# Statement of Common Ground with East Riding of Yorkshire Council (draft)

Revision ~~2~~3 (tracked)

~~September~~October 2025

Figure 1.2: Land Areas and Cable Routes Plan with Field Numbering System

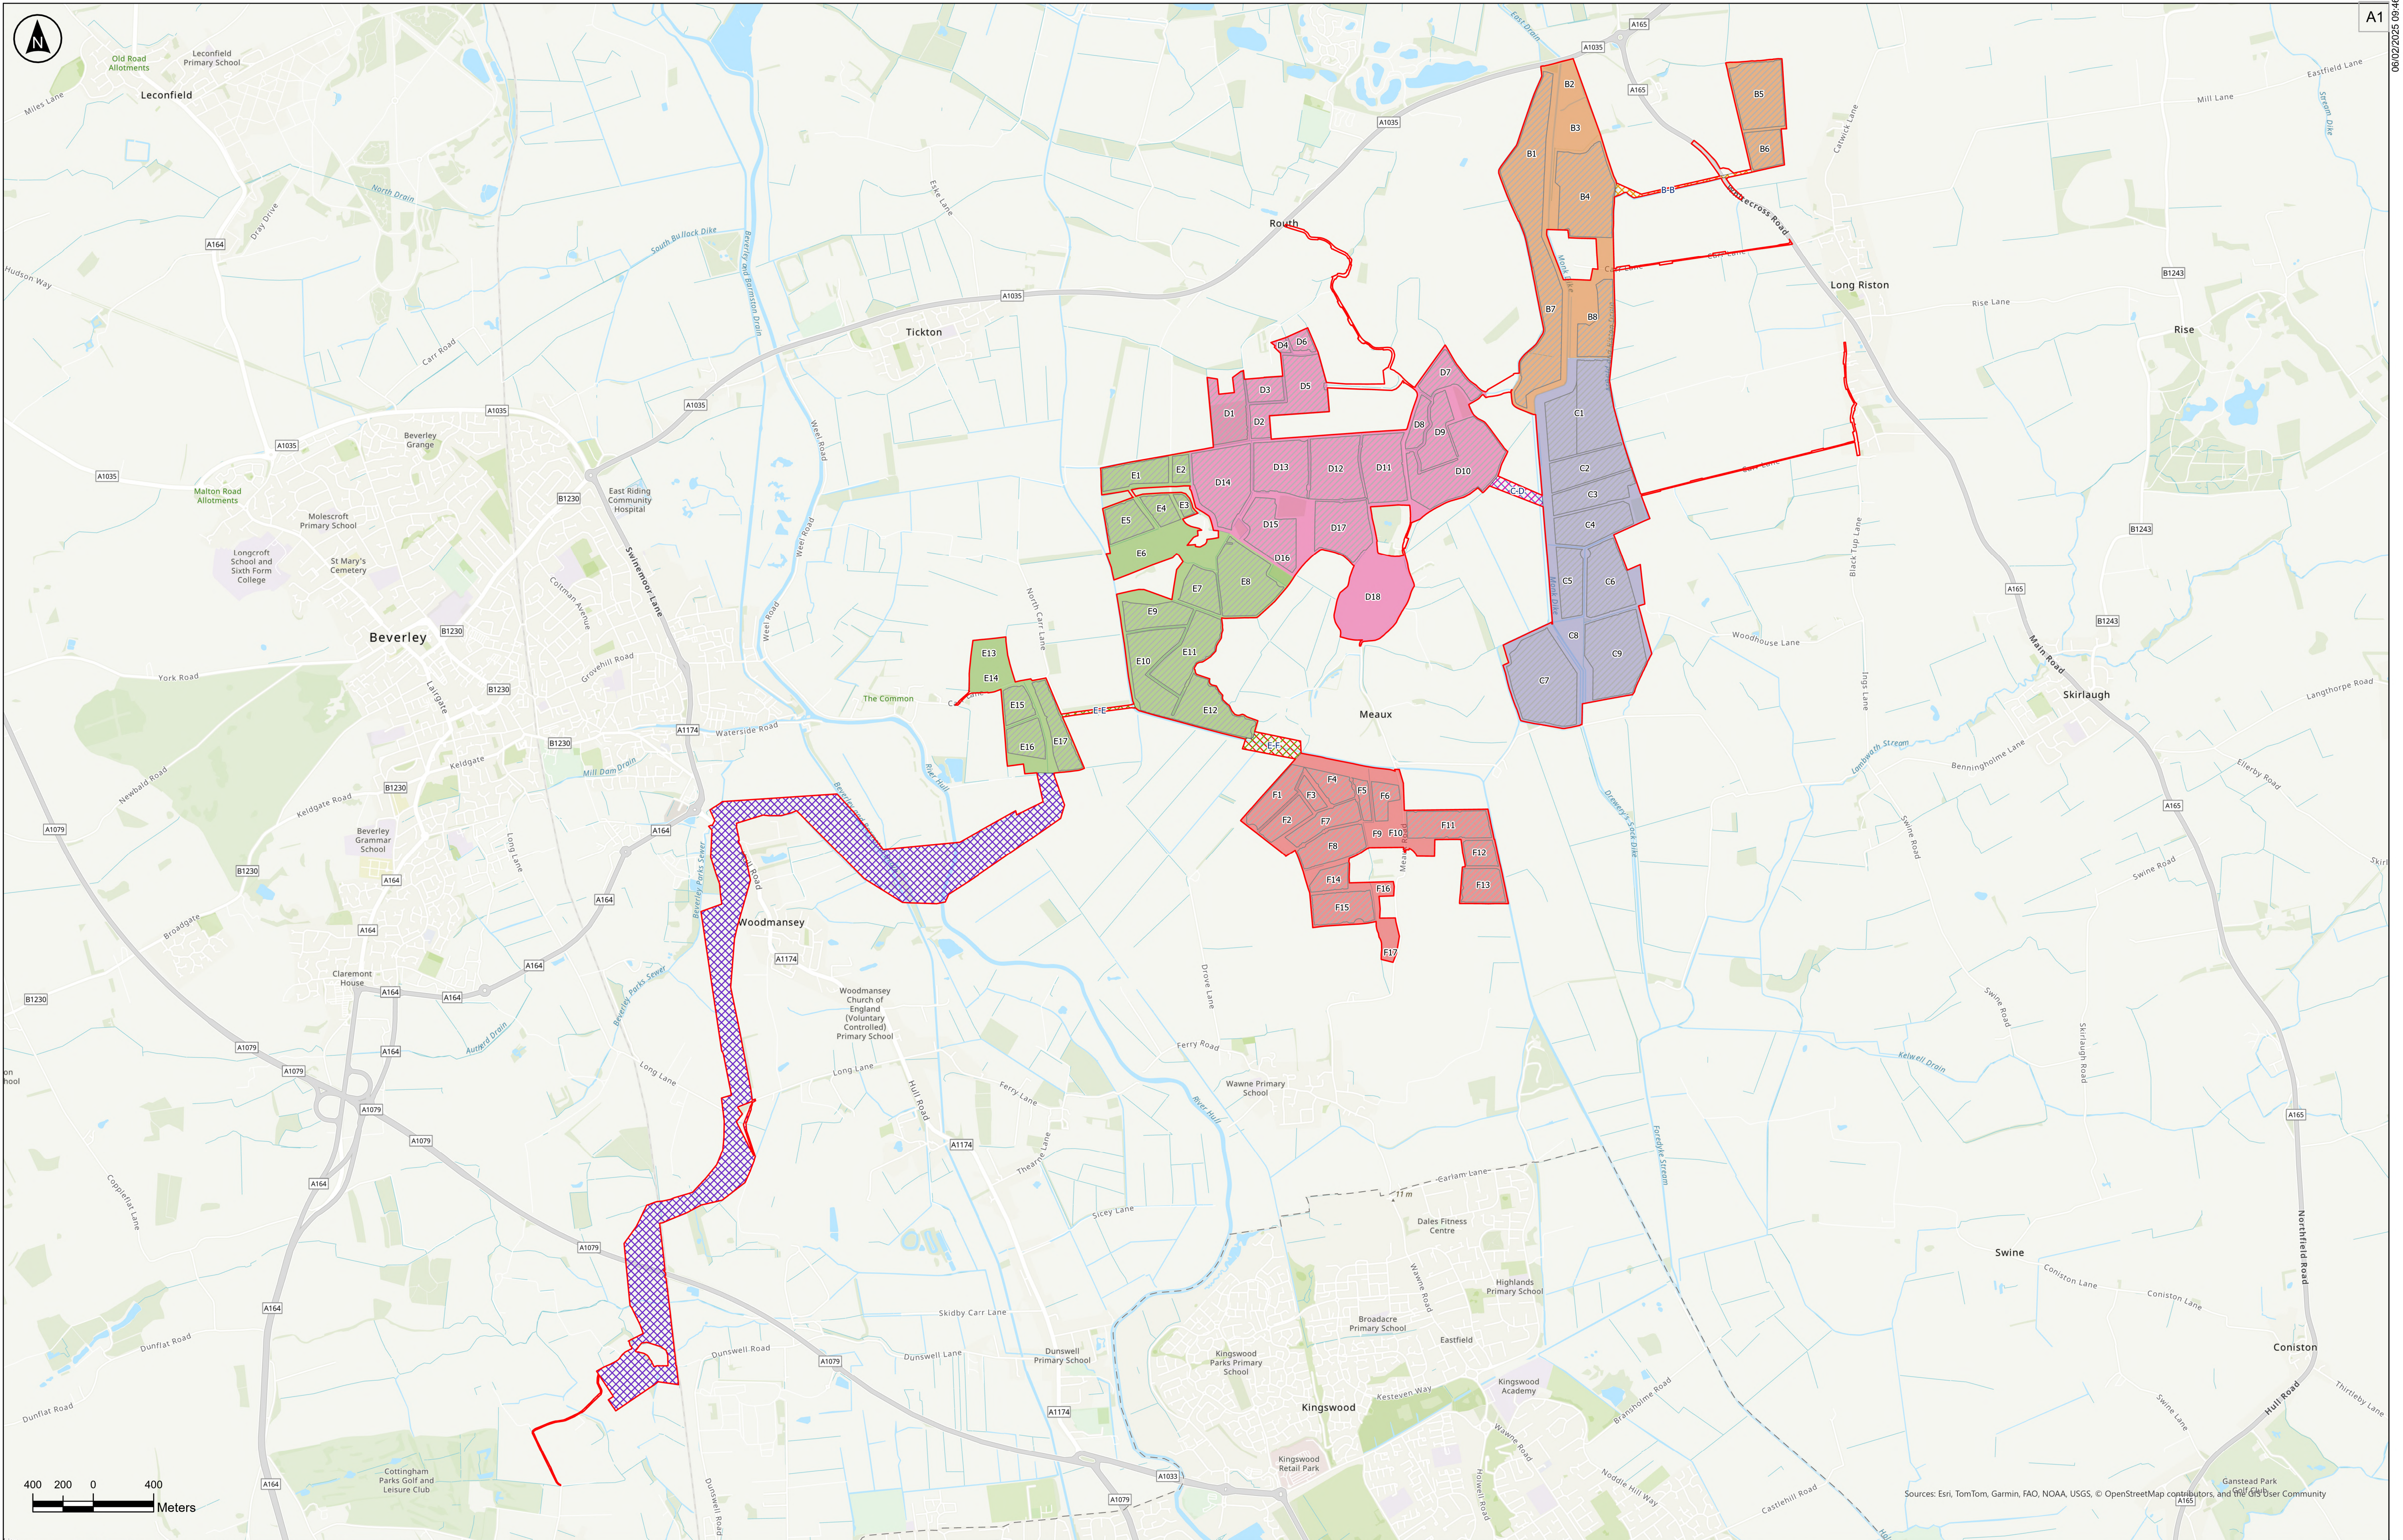
ERYC09	Protected sites – suitability of mitigation areas	East Riding of Yorkshire Council has concerns in relation to the extent of enclosure of mitigation area 11 (Field E6) and the introduction of permissive paths	<del>The Outline LEMP [EN010157/APP/7.5 Revision 3] has been updated to provide further assessment of the suitability and the potential carrying capacity of each</del>	Under discussion

Ref	Topic	East Riding of Yorkshire Council's Position	Applicant's Position	Status
	(enclosure and disturbance from recreational activities)  <i>Biodiversity</i>	<p>around mitigation areas 11 (Field E6) and 9 (Field D18), stating that the land needs to be reasonably open and human activity minimised.</p> <p>East Riding of Yorkshire Council notes that mitigation area 13 (Fields E13 and E14) is well-placed, has good likelihood for proposed scrapes to hold water, and that existing hedgerows do not pose a constraint to use.</p>	<p><del>mitigation area to deliver mitigation for the intended species. The updated document is submitted at Deadline 1.</del></p> <p><u>As set out in the <b>Third notification of proposed changes to the DCO Application [AS-017]</b>, the Applicant is proposing amendments to permissive path routes around mitigation areas, including mitigation areas 9 (Field E6) and 11 (Field D18), to address the matter of potential disturbance from path users (including dogs) on mitigation areas. The changes have been proposed following consultation with Natural England. The Applicant is also proposing to install 1m-high post and rail fencing with wire mesh between relevant sections of permissive path and mitigation areas to prevent path users and dogs straying into the mitigation areas, along with appropriate signage (to provide footpath users with information on the ecological importance of the mitigation areas and the countryside code which includes ensuring all dogs are kept on a lead). The Applicant is investigating ways to address issues of disturbance due to permissive paths around mitigation areas, such as the re-routing of the proposed permissive paths around mitigation areas 9 and 11, the use of signage in appropriate locations instructing dog walkers to keep their dogs on a lead and/ or additional fencing. The Applicant will continue to engage with East Riding of Yorkshire Council on this topic.</u></p> <p><u>Should the proposed changes to permissive paths be accepted by the Examining Authority, relevant documents would be updated as necessary and submitted at subsequent deadlines. The <b>Outline LEMP [EN010157/APP/7.5 Revision 3]</b> and <b>ES Volume 3, Figure 3.4: Indicative Environmental Masterplan [APP-058]</b> will be updated to reflect any changes as necessary and submitted at subsequent deadlines.</u></p> <p><u>Section 3.2 of the <b>Outline LEMP [EN010157/APP/7.5 Revision 6]</b> provides further information regarding the viability of the proposed SPA/Ramsar site mitigation areas.</u></p> <p>The Applicant will continue to engage with East Riding of Yorkshire Council on this topic.</p>
